Planning Application Reference No.: 3/2022/0837

Address of Development: Inglemead, Waddington Road

[REDACTED] have the following comments about planning application number 3/2022/0837 – Proposed two storey rear and side extension and replacement of the front elevation porch at Inglemead, Waddington Road, Clitheroe BB7 2HN. Inglemead is the semi-detached house [REDACTED]

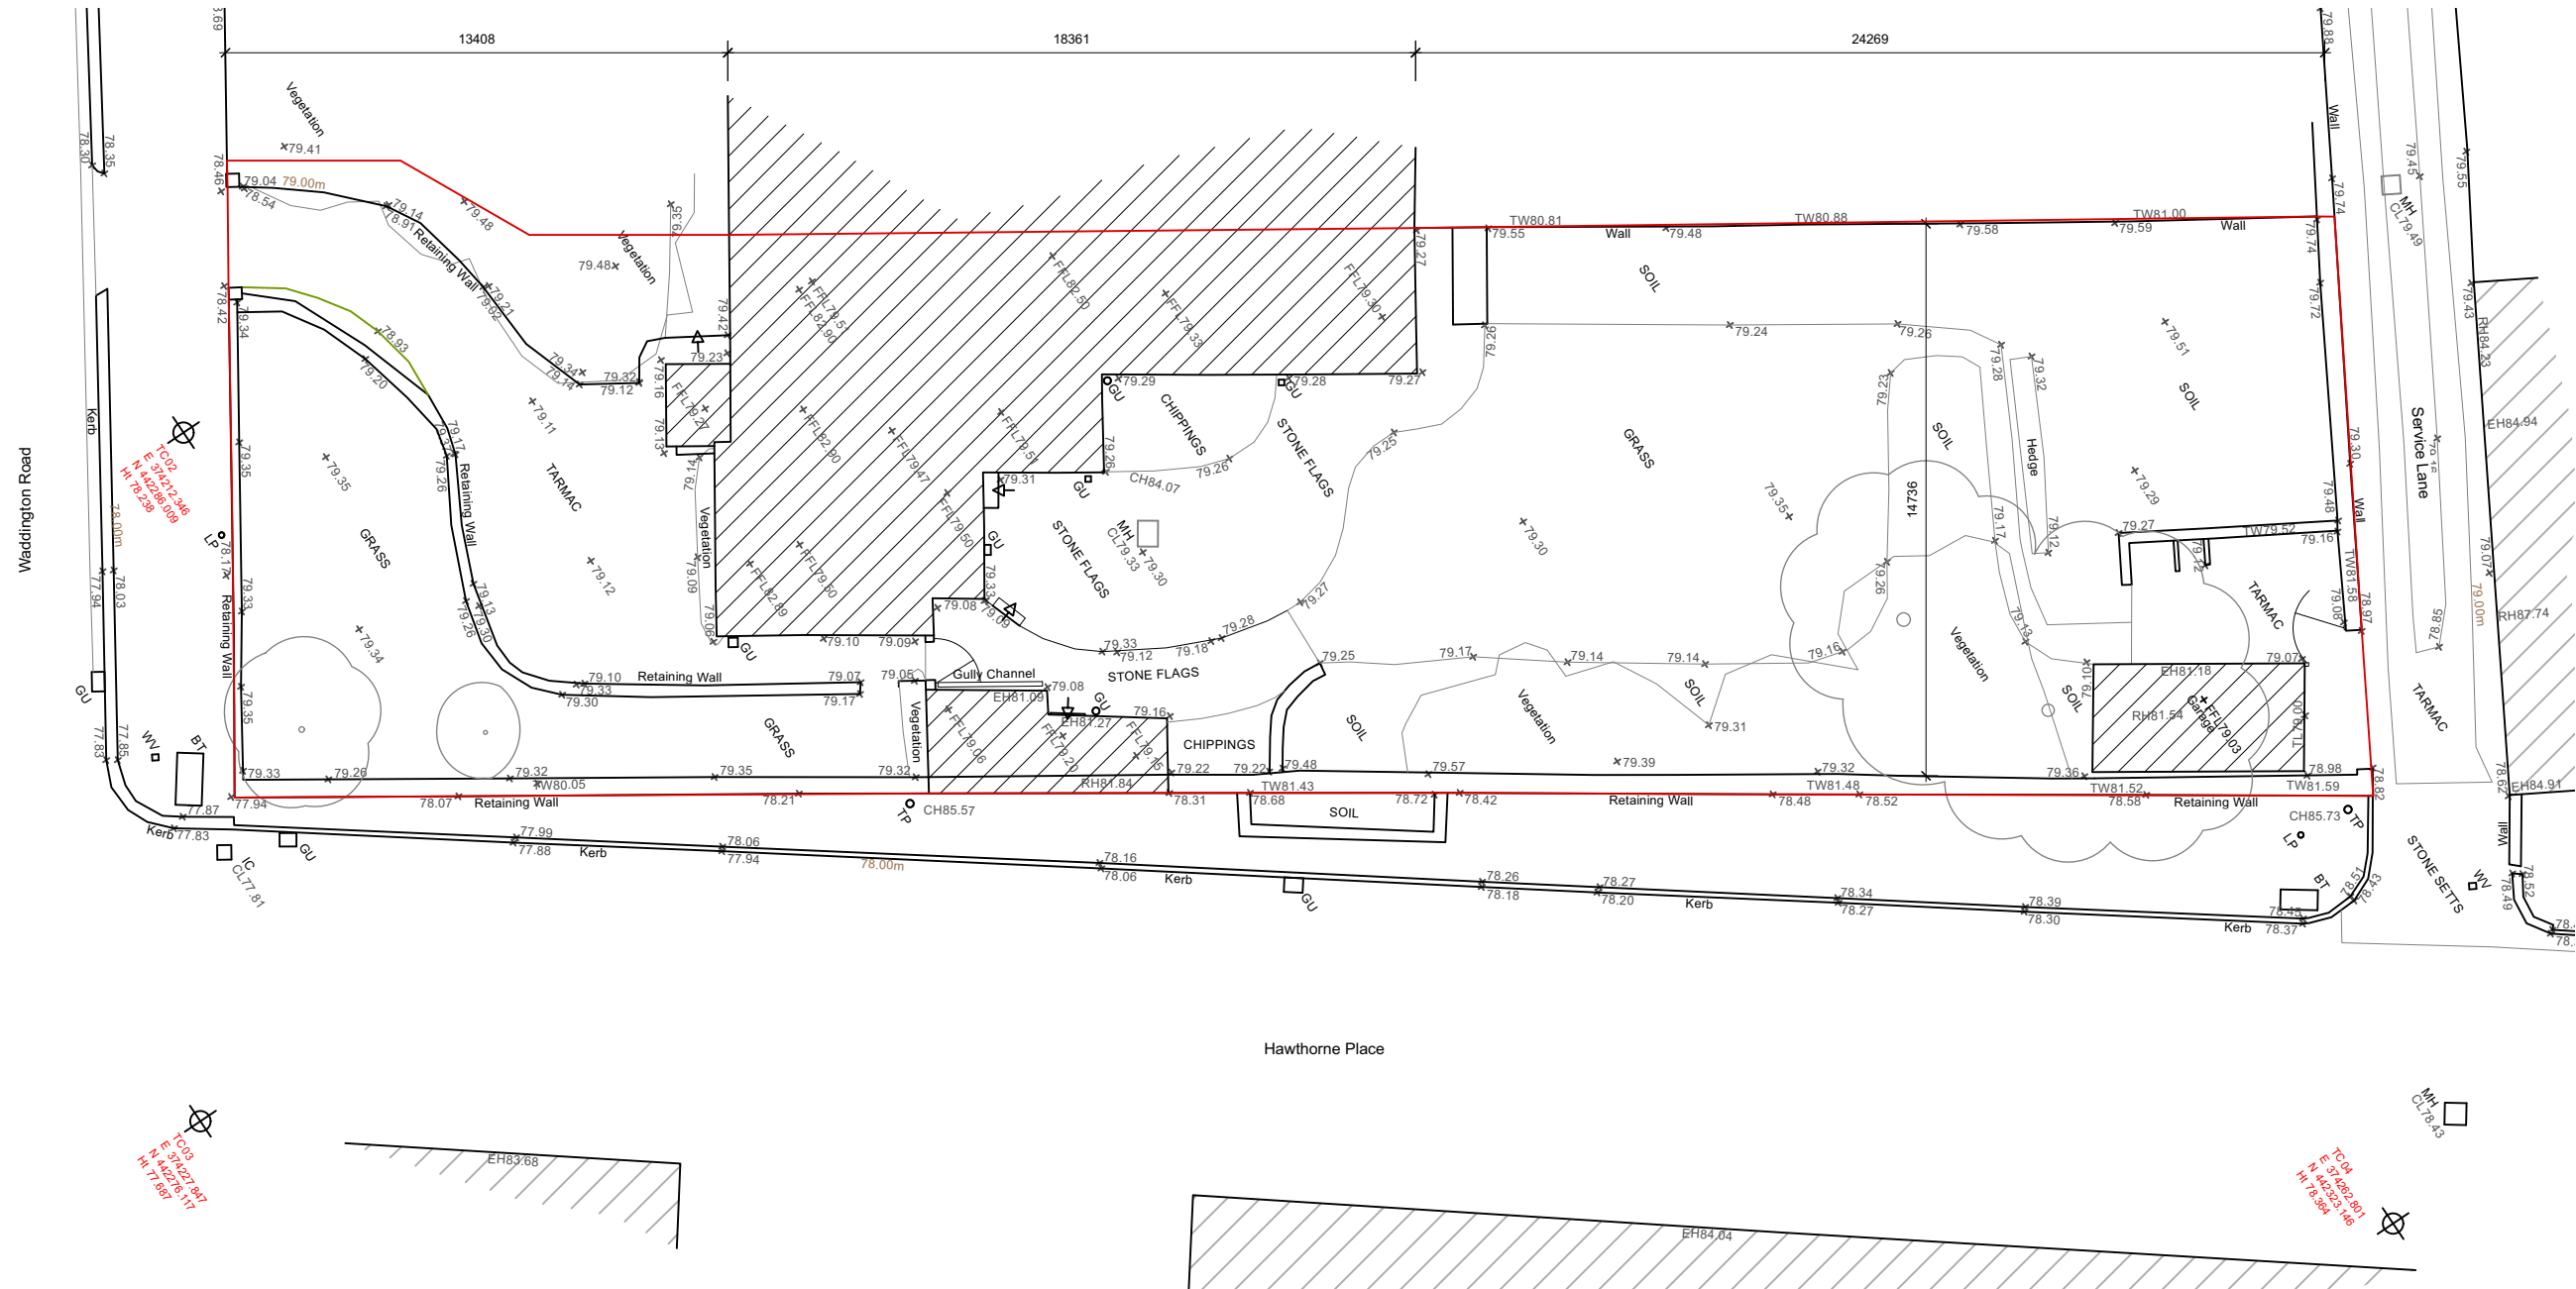
On the Existing and the Proposed Site Plan, although not of relevance to the current planning application, it must be noted that we believe that the red boundary line at the front of the property is drawn incorrectly.

1 PROPOSED SOUTH EAST ELEVATION
Scale: 1:100

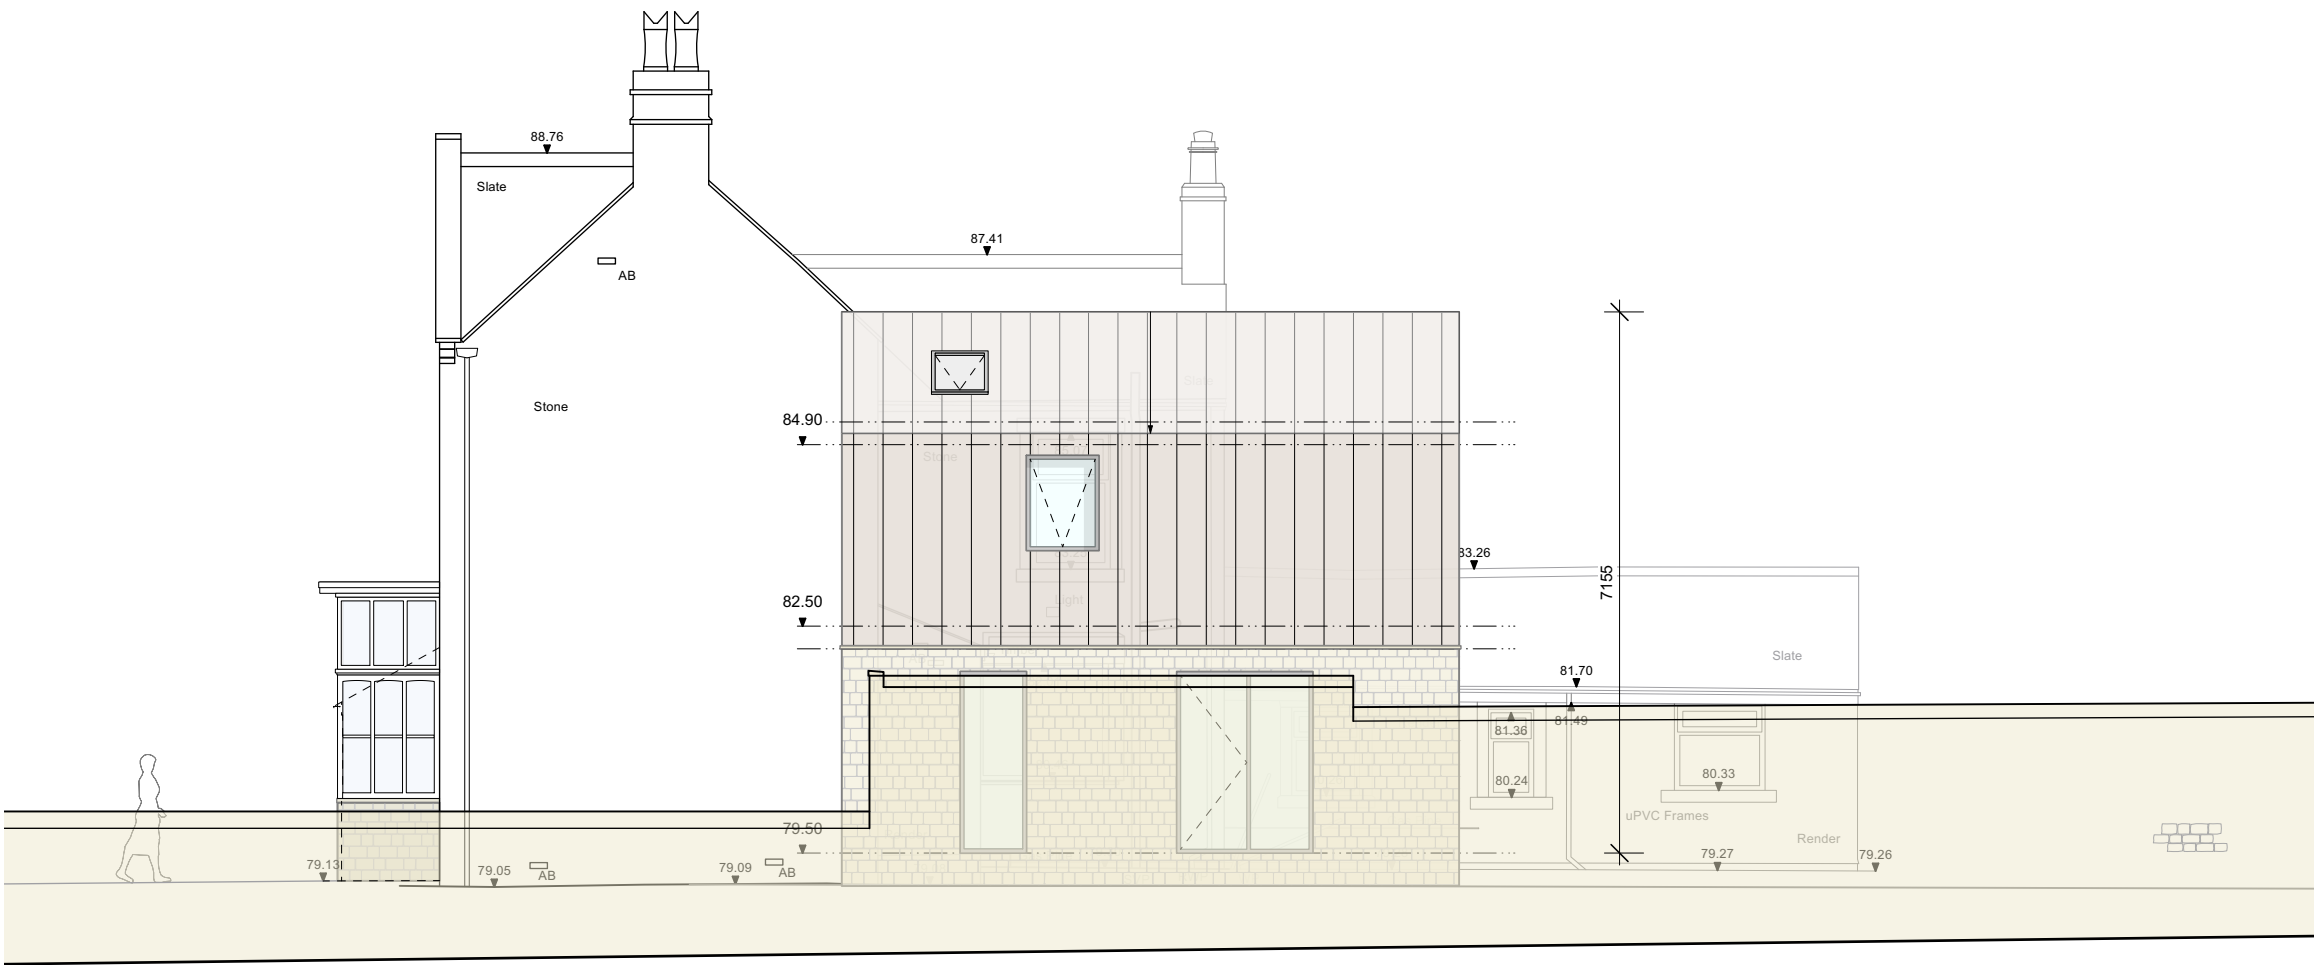
[REDACTED] do not have any objection in principle to the intended works to the property however do wish to express some concern about the materials being chosen for the extension, particularly at first floor level.

The brief details that this will be of 'standing seam sheet metal in bronze'. This is of course a modern and contemporary finish. Due to the age of the building it would be preferable in [REDACTED] view to utilise more traditional building materials that are more in keeping with the surrounding vernacular. Clearly there is a desire when extending buildings to not always seek to 'exactly match' the existing building to show the progression of development. However, at this site the use of the intended materials would not be in keeping with the surrounding buildings which are of a very similar age and are constructed from very similar materials.

It appears that the front porch will be demolished and rebuilt on the drawings, but this is not described, other than some materials in the application form. It is unclear what part of the porch some of these materials are used for or what the solid base of the porch is constructed from. We would welcome a description of the materials proposed to be used for the front porch renovations. Especially with the front elevation of this age of property, this must be in keeping with a period property.
